Rezoning Transportation Analysis
Petition Number: Insert Zoning Petition #2021-259
General Location Identifier: 07908701, 07908702

Revision Log:

Date	Description
04-28-22	First Review (PDM)
05-26-22	Second Review (PDM)

**REZONING PLAN
RZ.01**

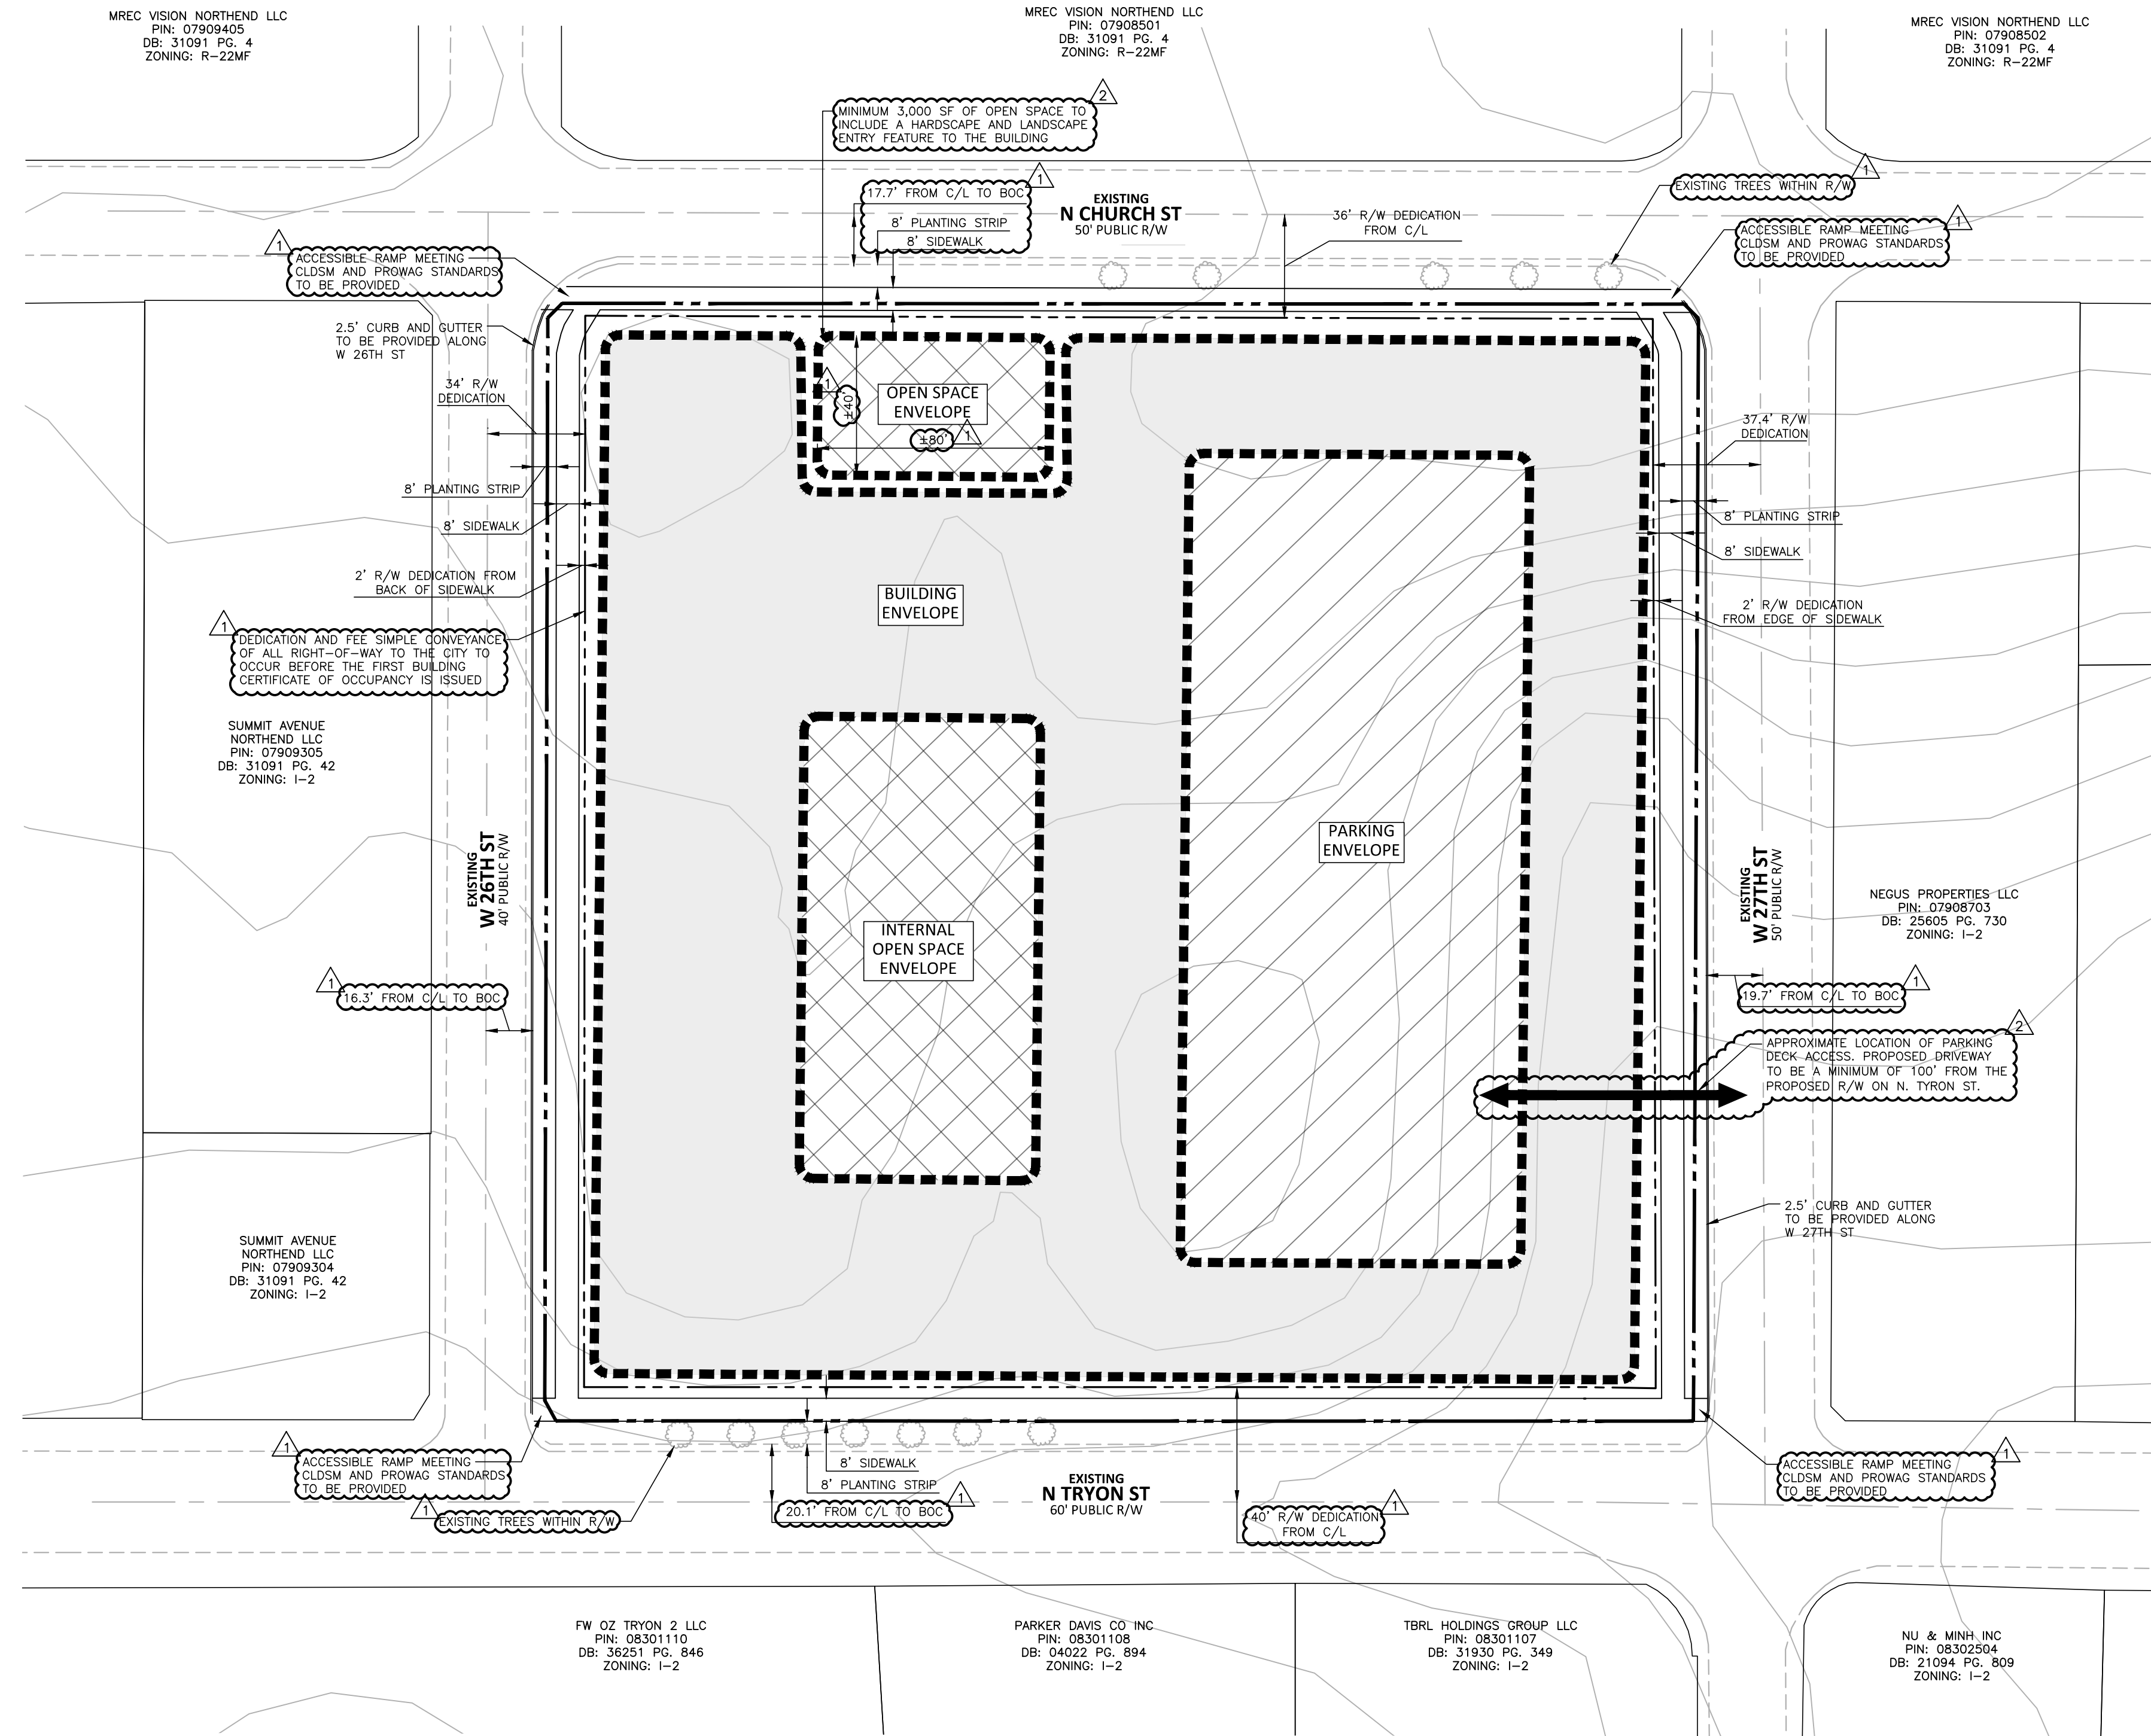
location to provide a minimum 100ft protected stem on 27th Street from North Tryon Street. Further details are listed below.

10. **NEW COMMENT 5.26.2022:** Per NCDOT requirements, revise proposed driveway location on 27th Street to be a minimum of 100ft from the proposed ROW on North Tryon.
